From: Tom Errico <thomas.errico@tylin.com>
To: Jean Fraser <JF@portlandmaine.gov>
Date: 8/4/2014 3:28 PM
Subject: 122 Anderson Street

Jean - I reviewed the application materials for the project and offer the following final comments and conditions of approval for the project.

DIRECTIONS TO THE INTERMODAL TRUCK STAGING YARD:

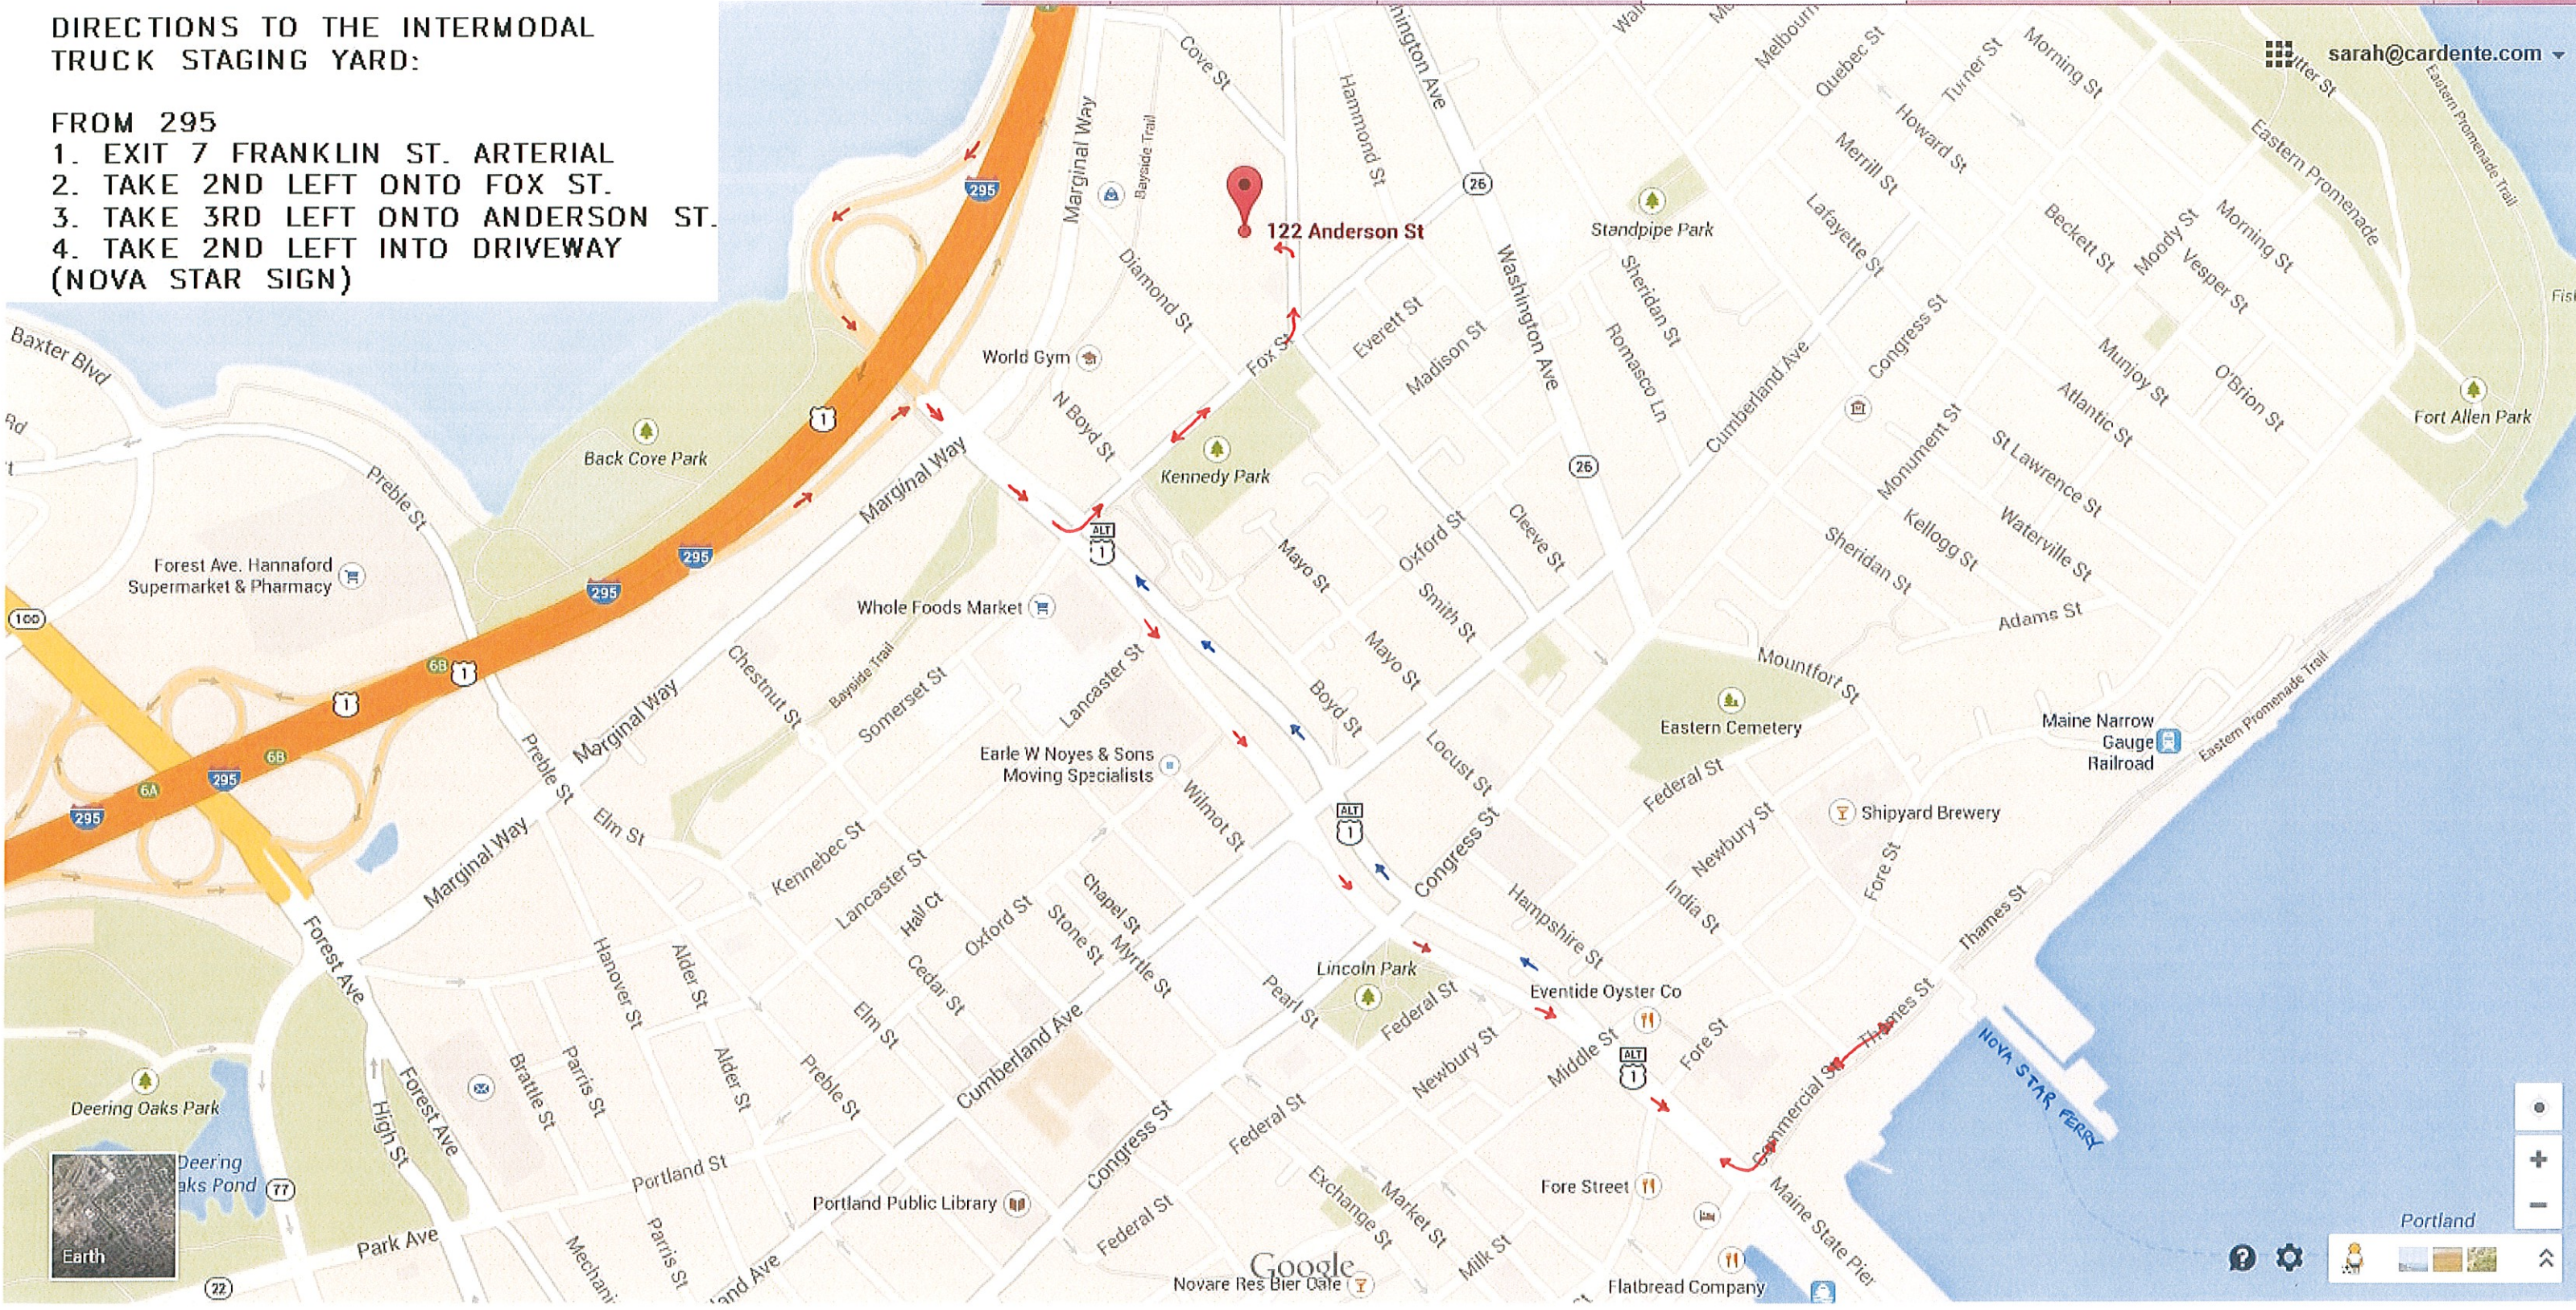
- * The applicant has suggested a routing plan from 122 Anderson Street to Fox Street and Franklin Street. I find this routing to be reasonable given the driveway geometric alignment (left-turn exit movements and right-turn entry movements would be problematic). Accordingly, the following recommendations are based upon this routing.

- * The applicant shall implement a departure management plan that limits the truck departure rate to a one truck per minute or more. The westbound Fox Street signal phase at Franklin Street will not likely be able to process more than one truck and therefore is currently a limiting factor. The monitoring study will review this departure rate and recommend adjustments, as necessary.

**C1.3**

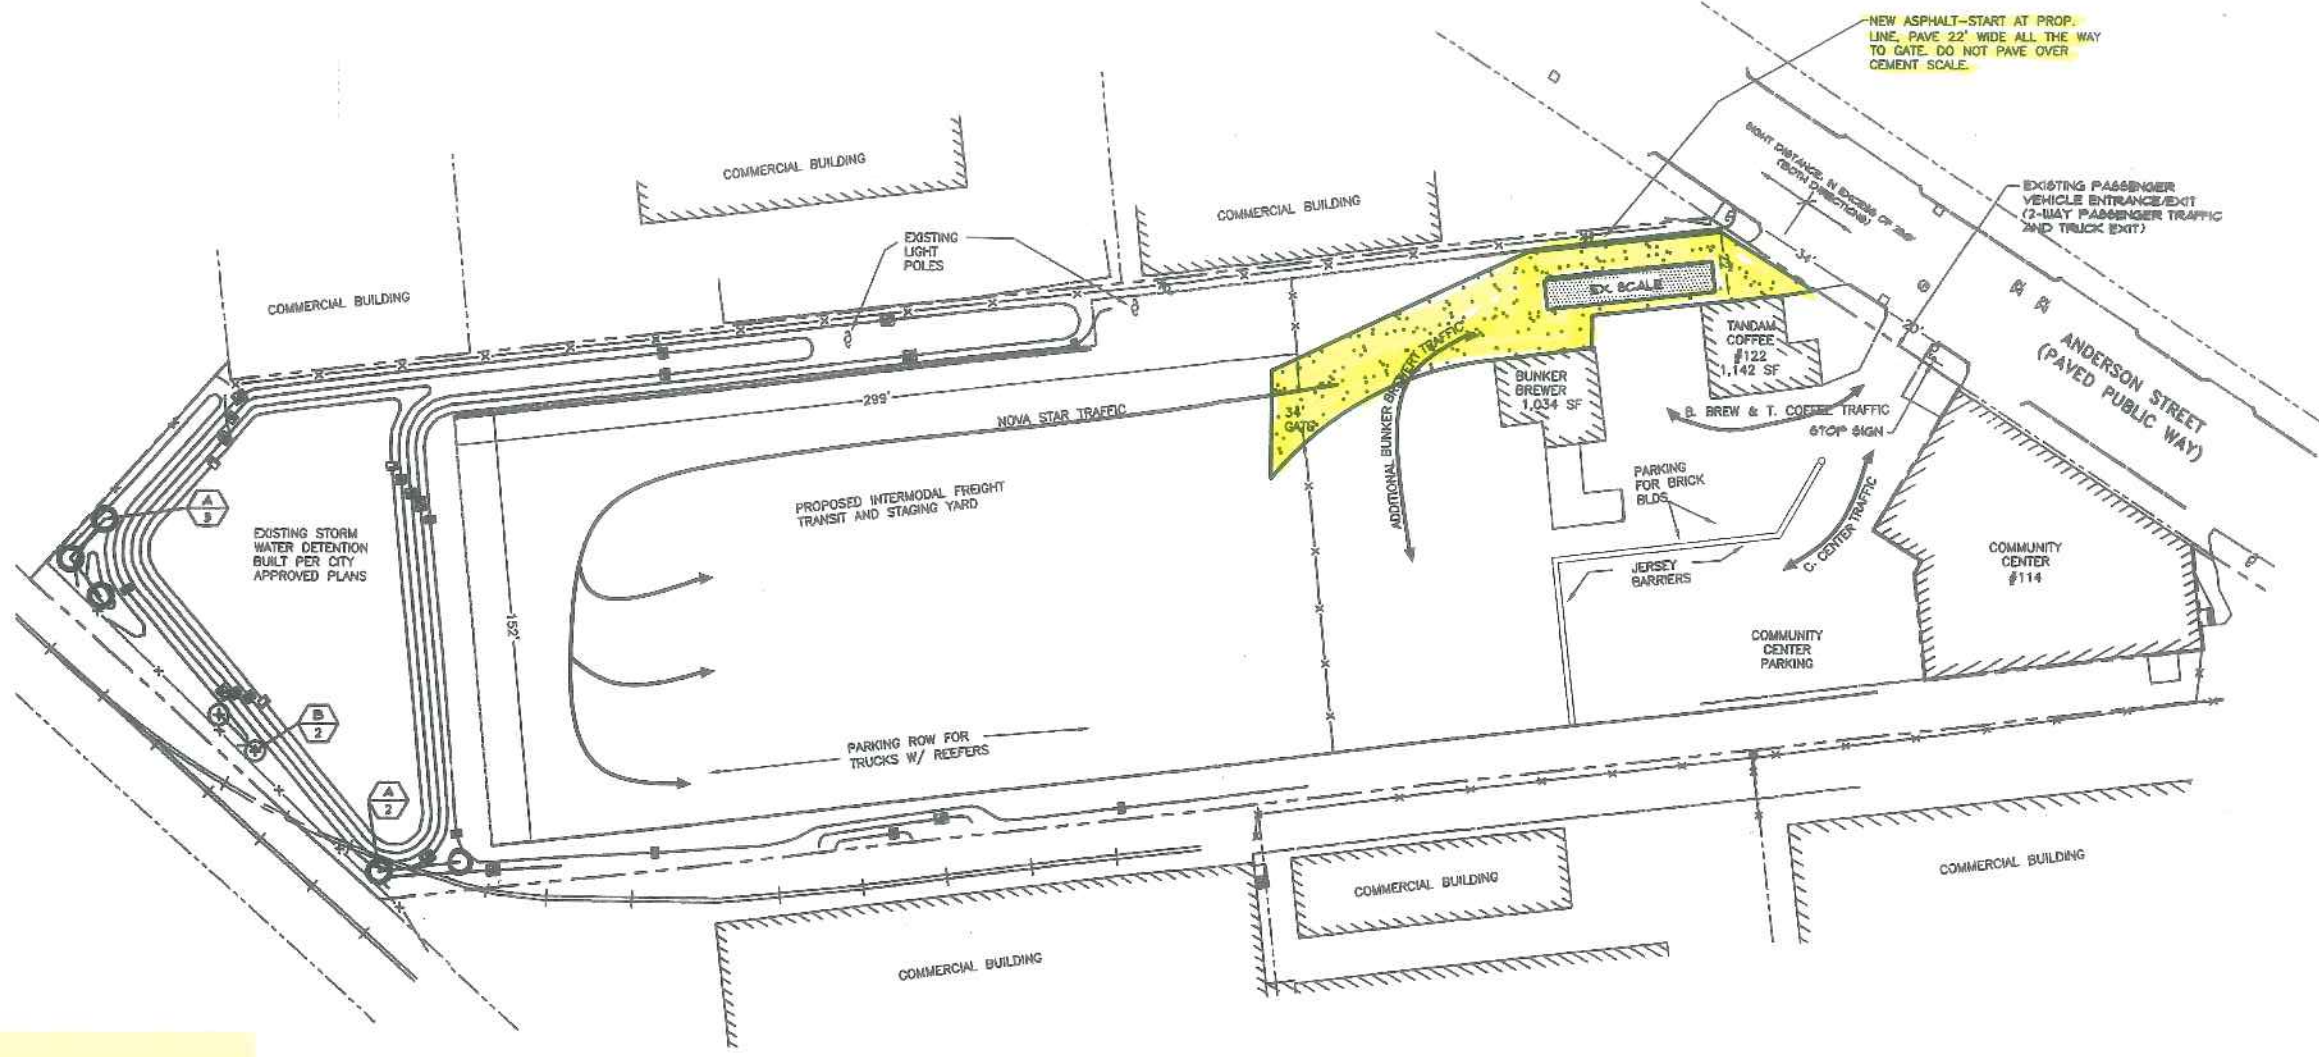
- * The applicant shall be responsible for providing a fully paved driveway of a minimum width of 22 feet wide from the right-of-way boundary extending into the site for 50 feet. A plan of this improvement shall be provided for review and approval.
